Re Architectural Design Statement - Response to SSD submissions

Further to the receipt of the submissions to the SSD for Shore Physical Education Centre we have the following responses.

1 PLAN - 21 MARCH - 12:00 NOON -
SHADOW CAST BY PROPOSED BUILDINGS
SCALE 1 : 400

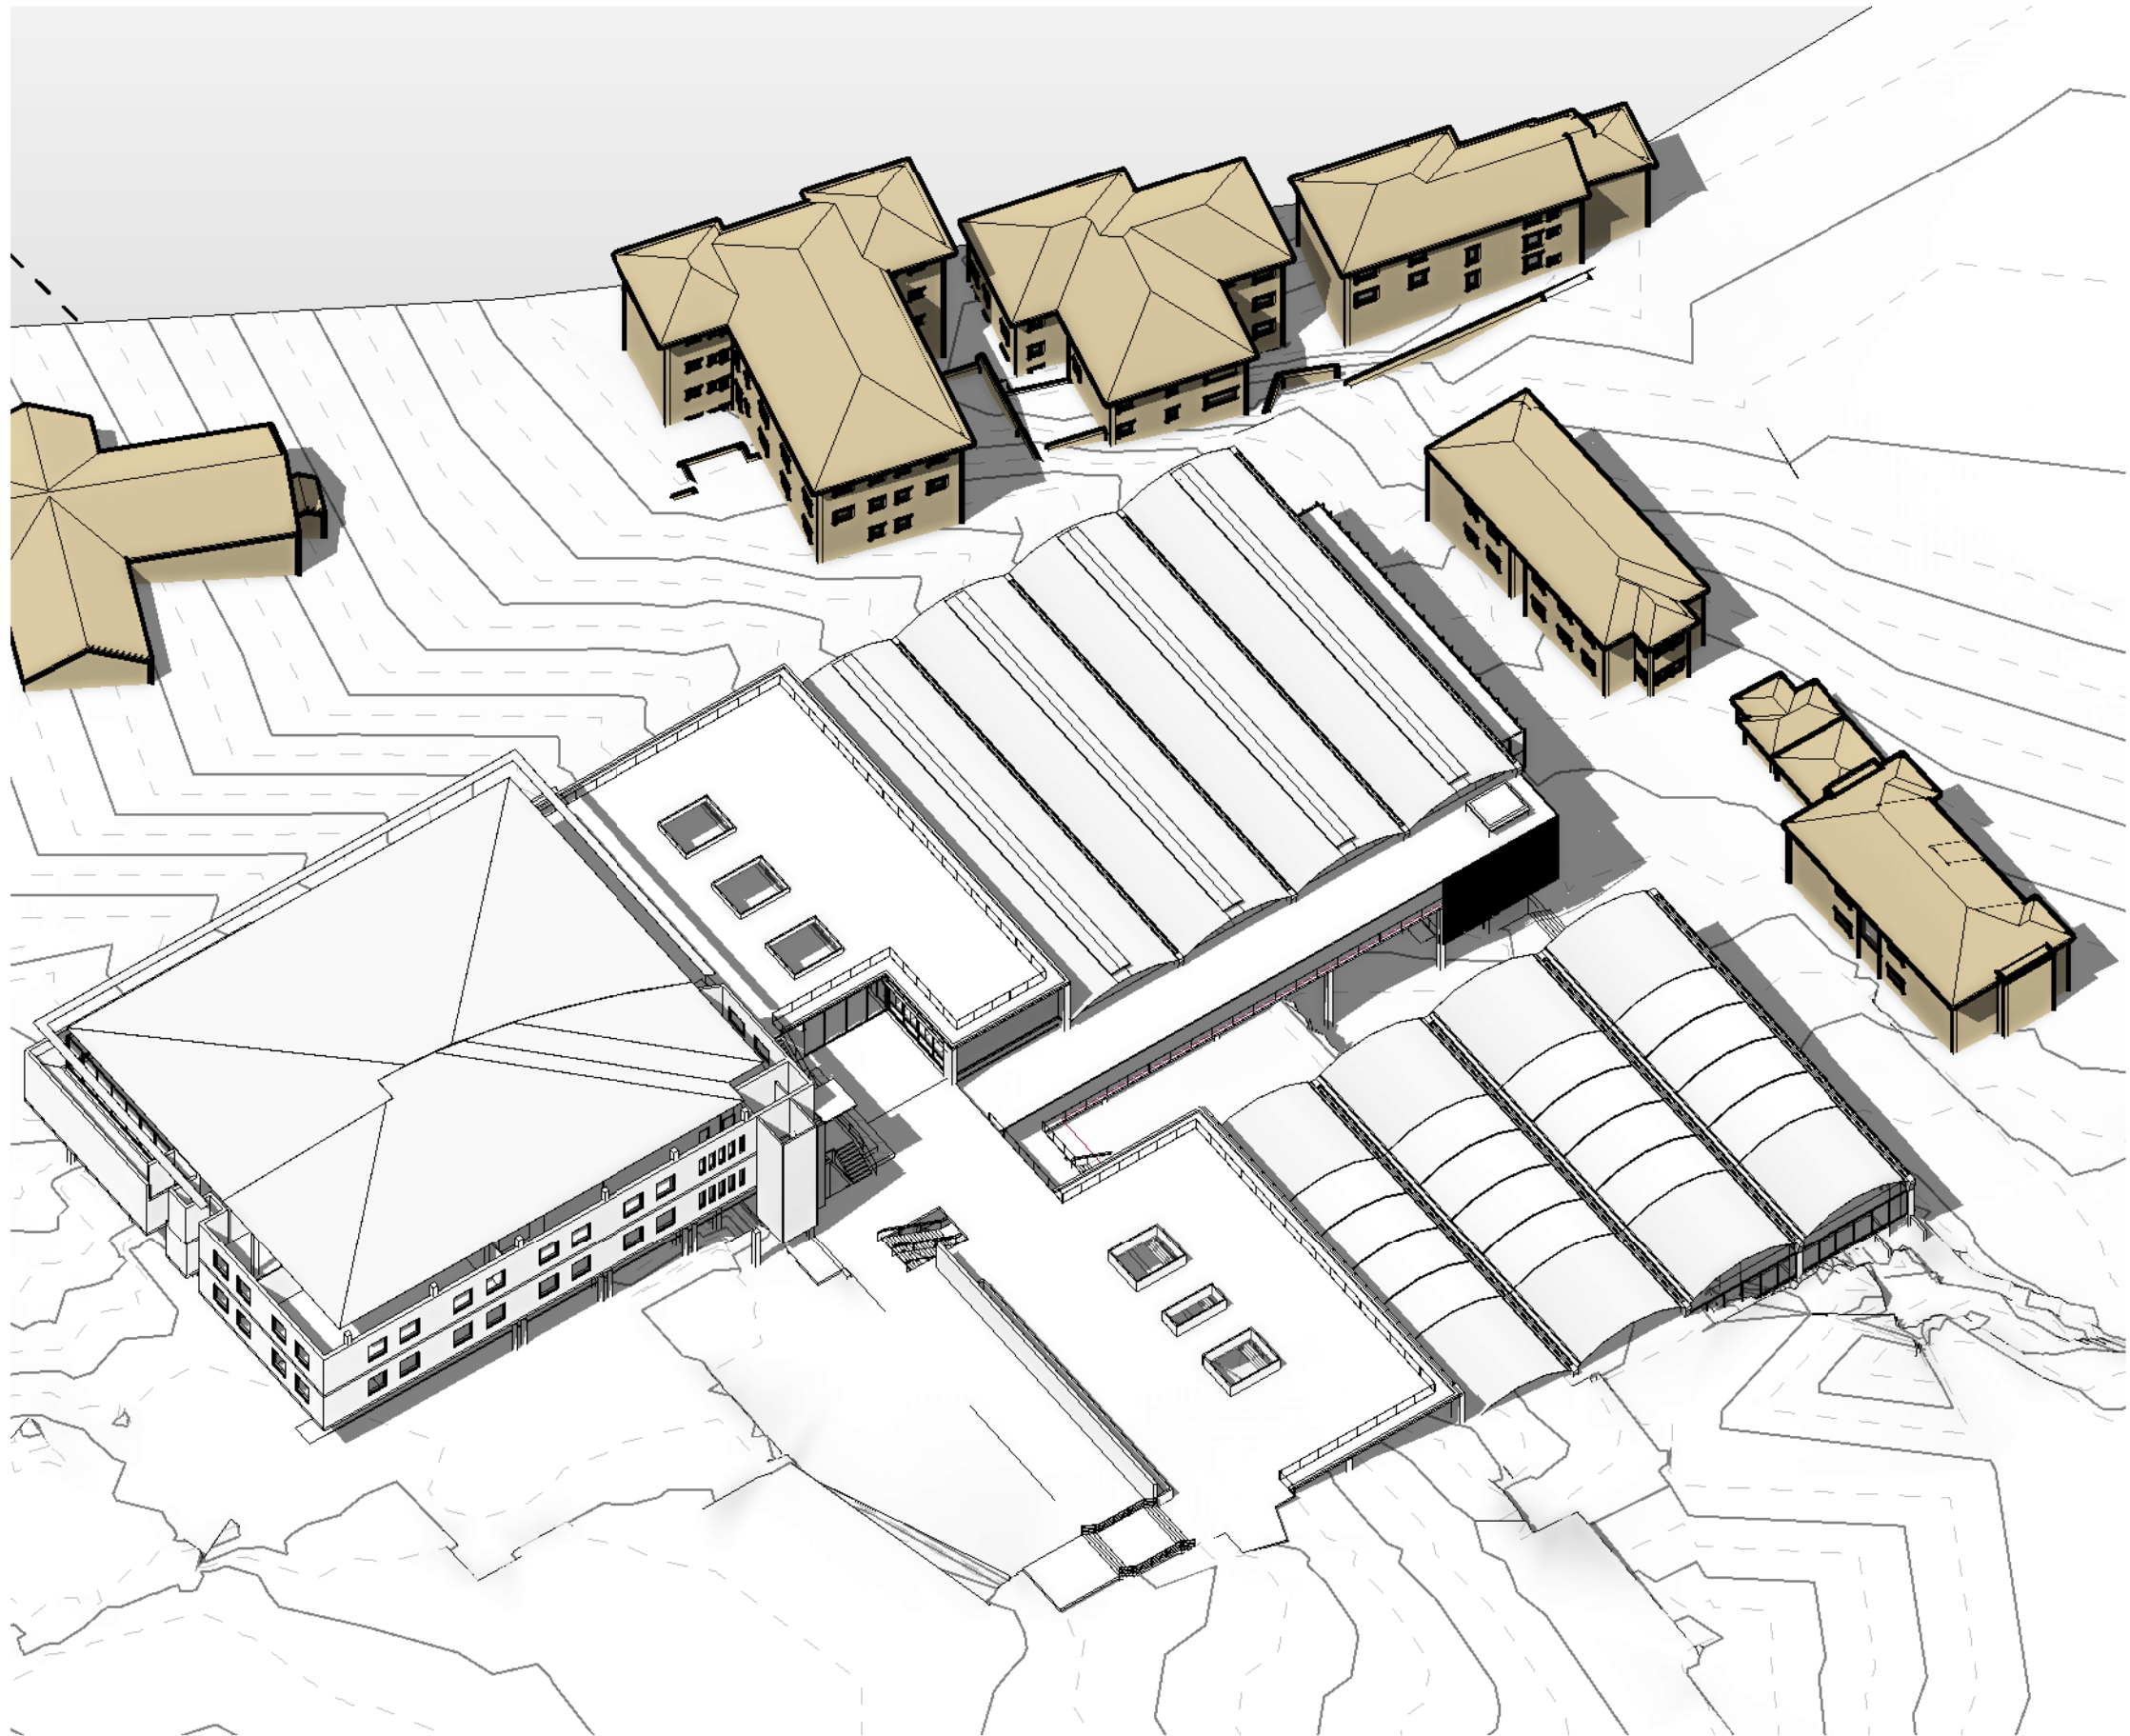
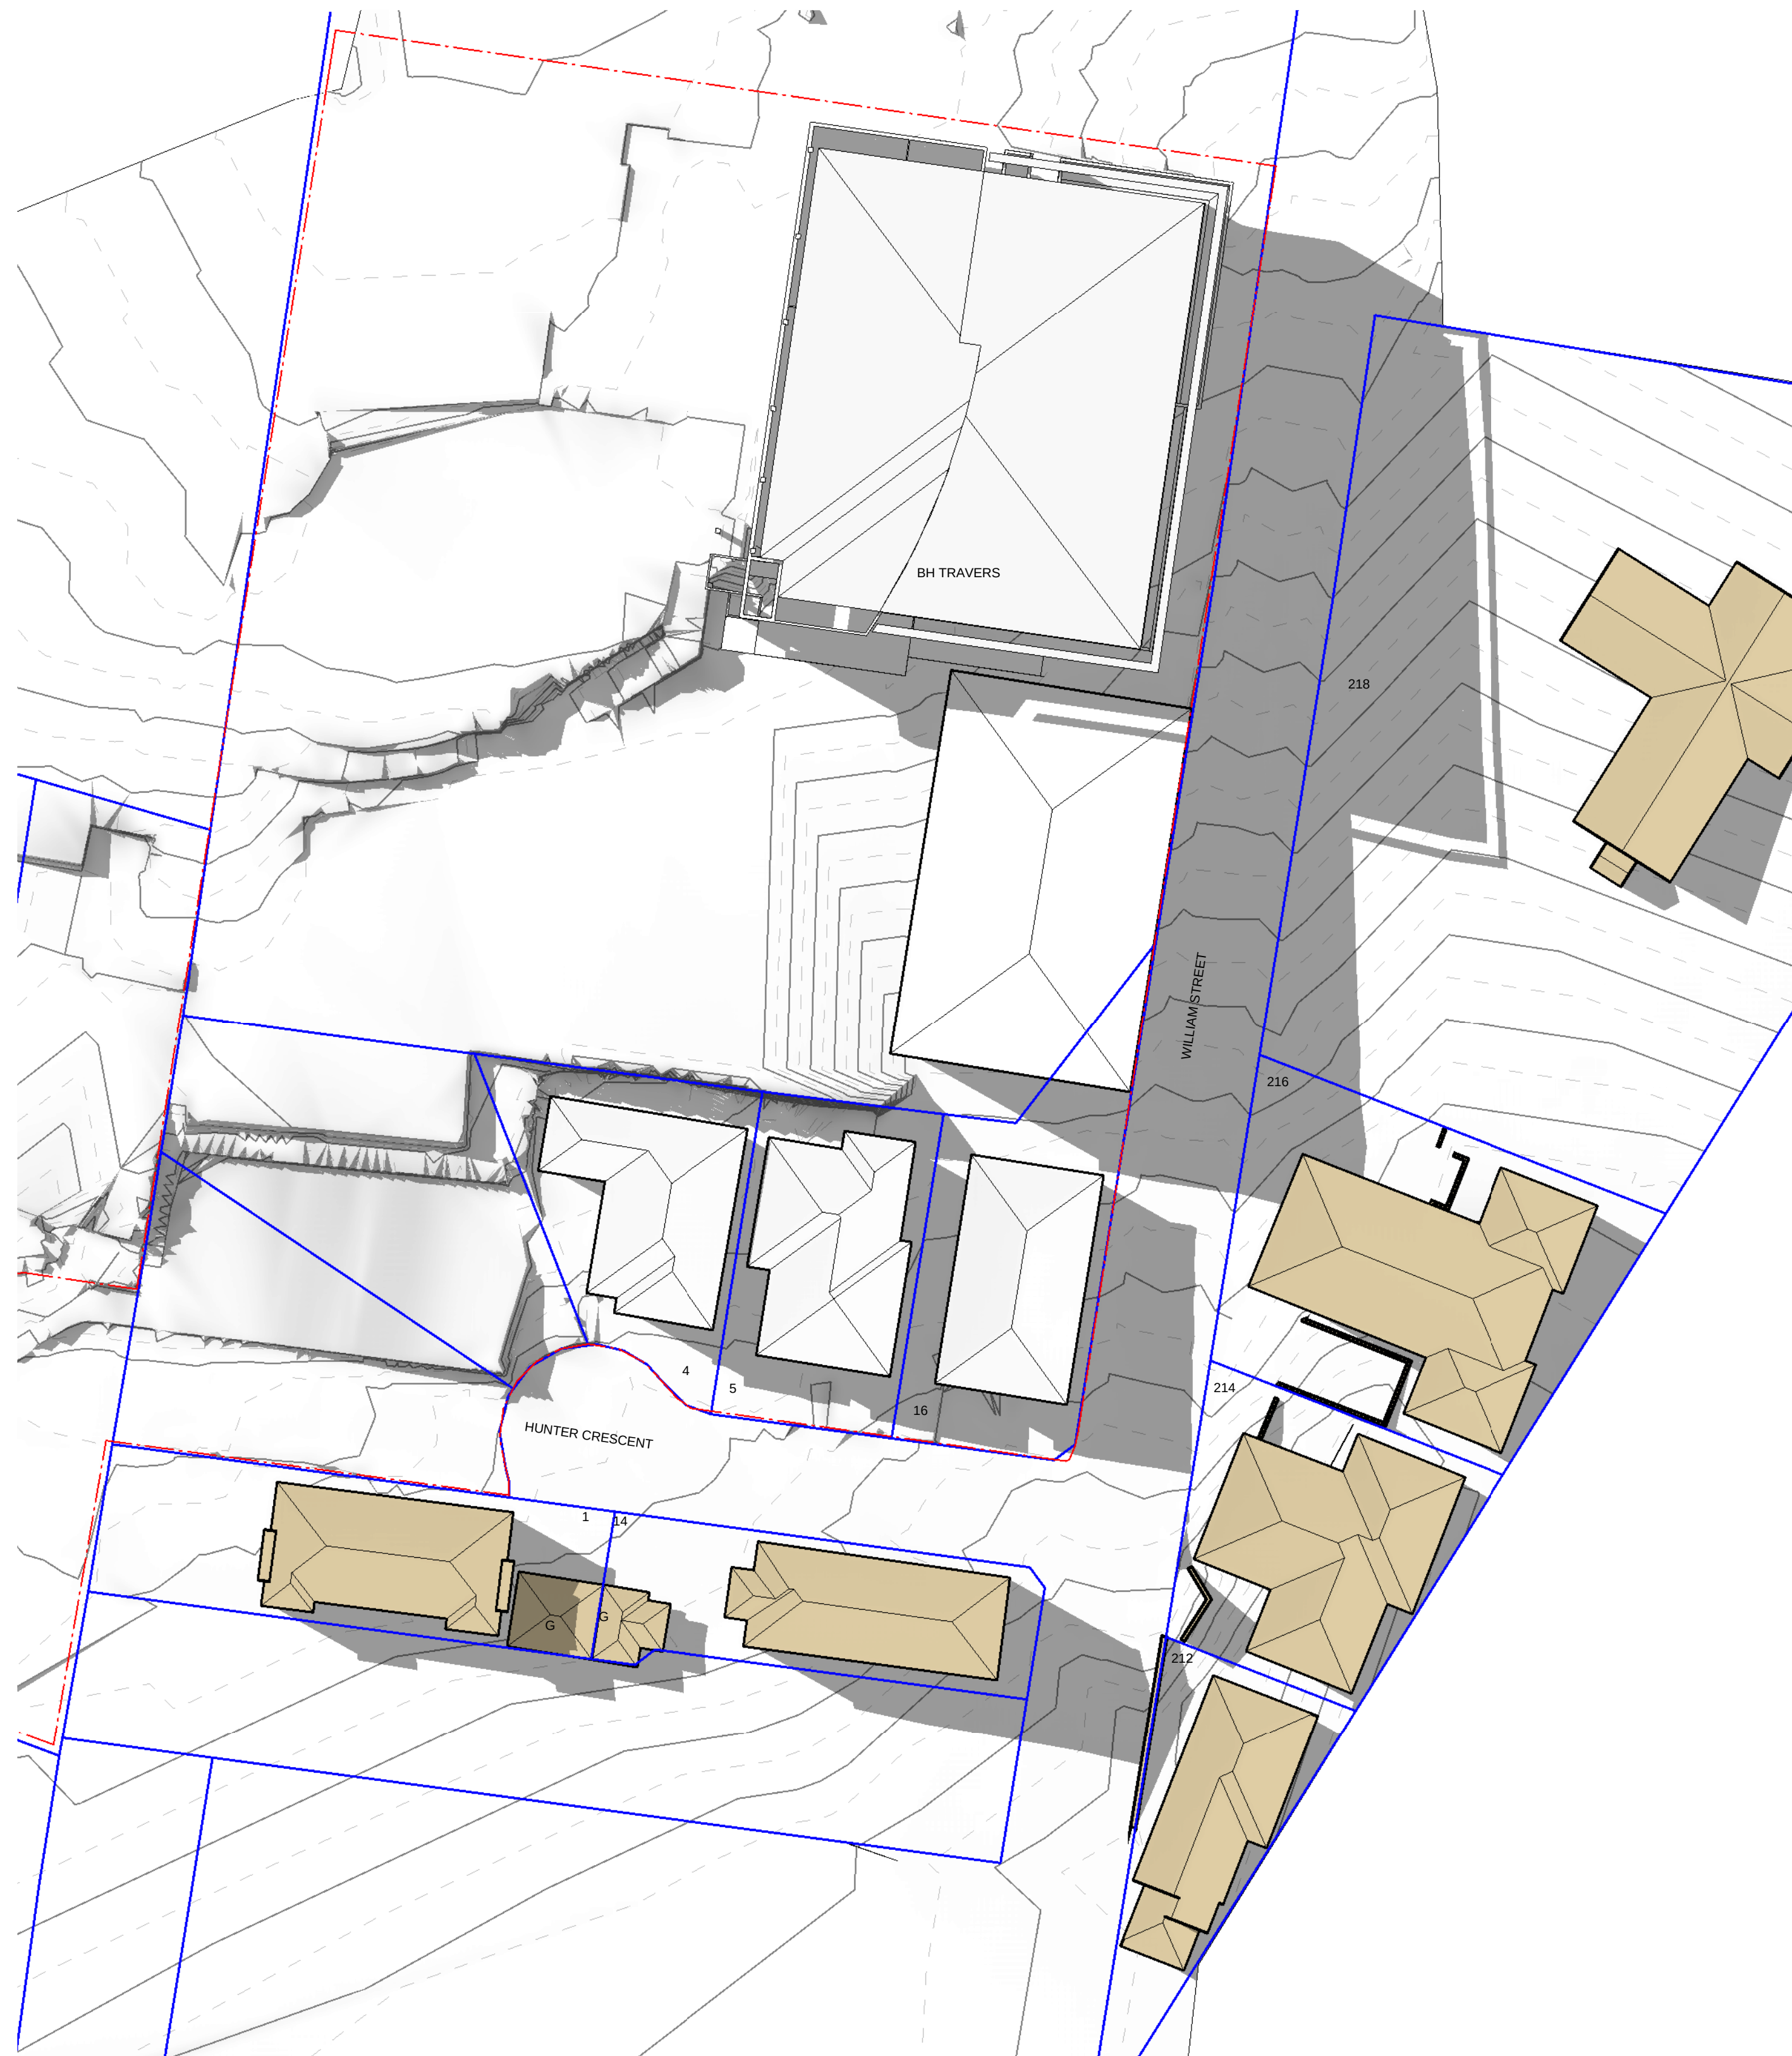
The shadow diagrams provided in the SSD submission provide evidence of the windows to habitable rooms that are impacted by overshadowing, with a comparison with those of a compliant height development. There is little difference between the compliant height development shadows and the proposed SPEC.
